Site:	Lidsey Road, Woodgate
App. No:	AL/57/18/OUT
Status:	Outline permission with aspects of appearance reserved for later determination
By:	D. Edwards
Date:	29 th October, 2018

Drawing Title Proposed 3 Bed Type 2 Plans & Section
Address Land at Woodgate, Westergate
Client Tim Johnson
Scale 1:100
Stage PLANNING
Drawn by sjd
Checked by ns

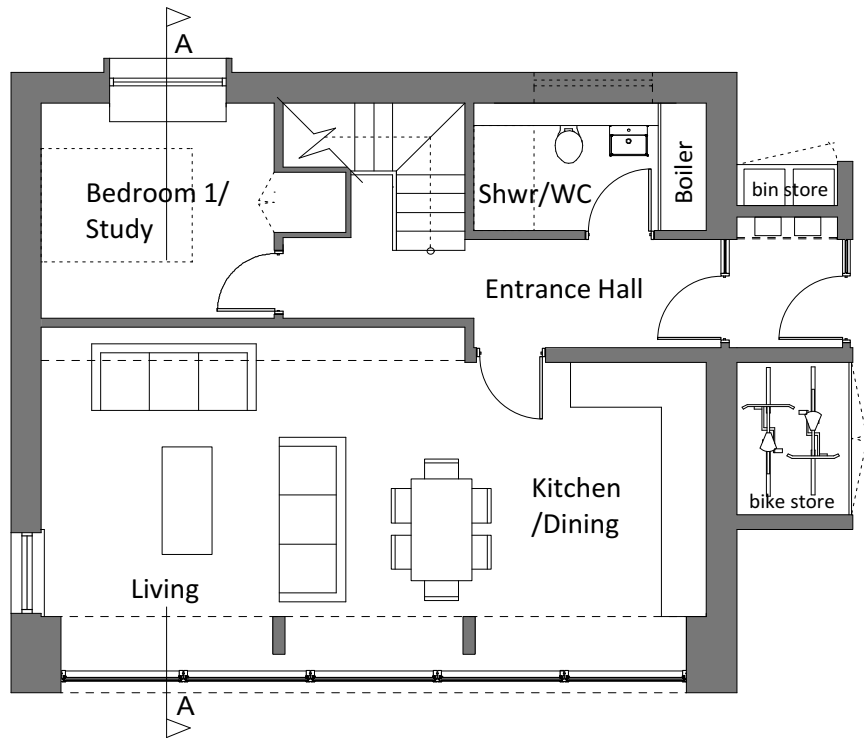
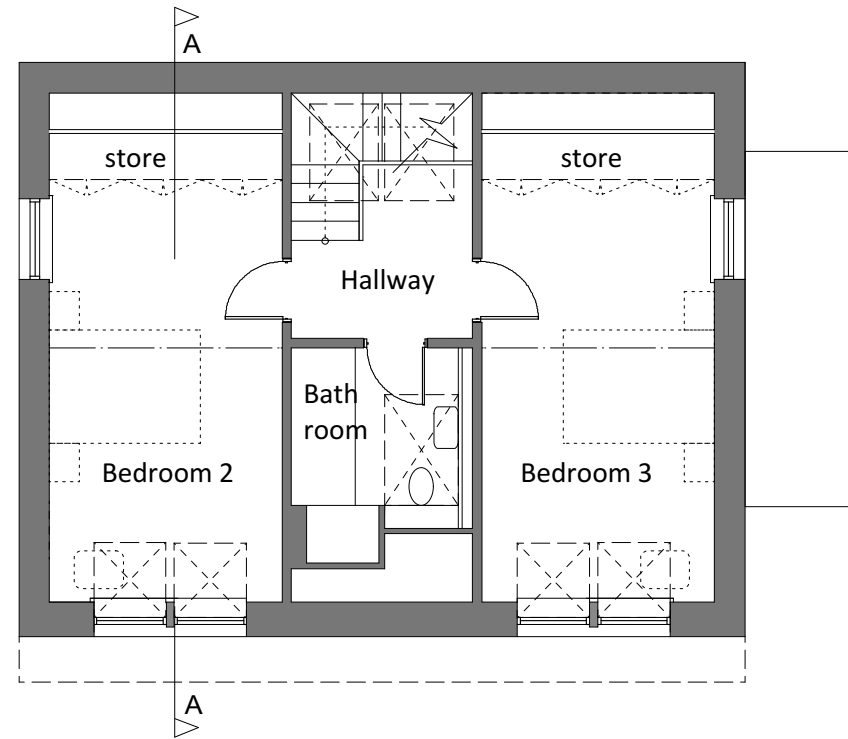
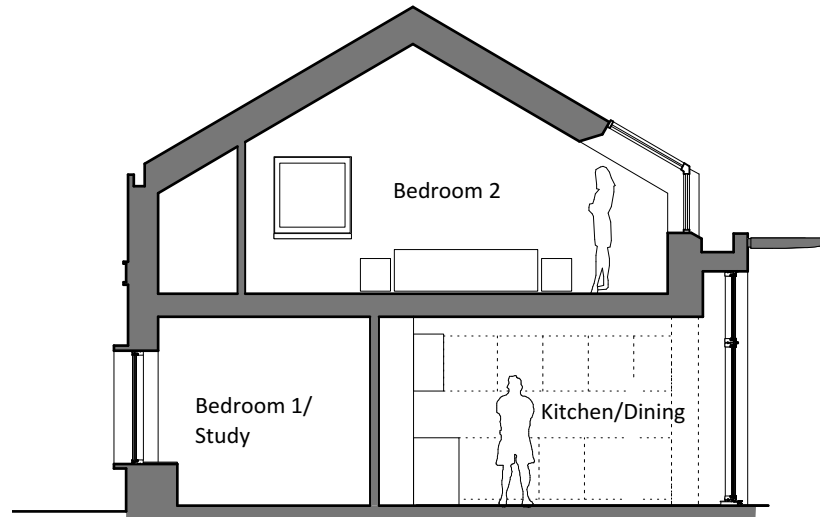
- While the contemporary building style and sustainable design features are certainly interesting, in reality, these have a limited relationship to the character, style and massing of neighbouring buildings; all neighbouring buildings appear to be 1 or 1.5 floors with pitched roofs while all proposed buildings are two stories with flat roofs.
- Similarly, it is unclear how the proposed treatment of new homes relates to the wider built form context.
- If a principal intent is to maximise solar gain and minimise heat loss, there appears to be limited variation between the proposed north and south elevations.
- West elevations have limited openings, which, given the visibility of these across the plan, negatively impacts passive surveillance of areas of open space.
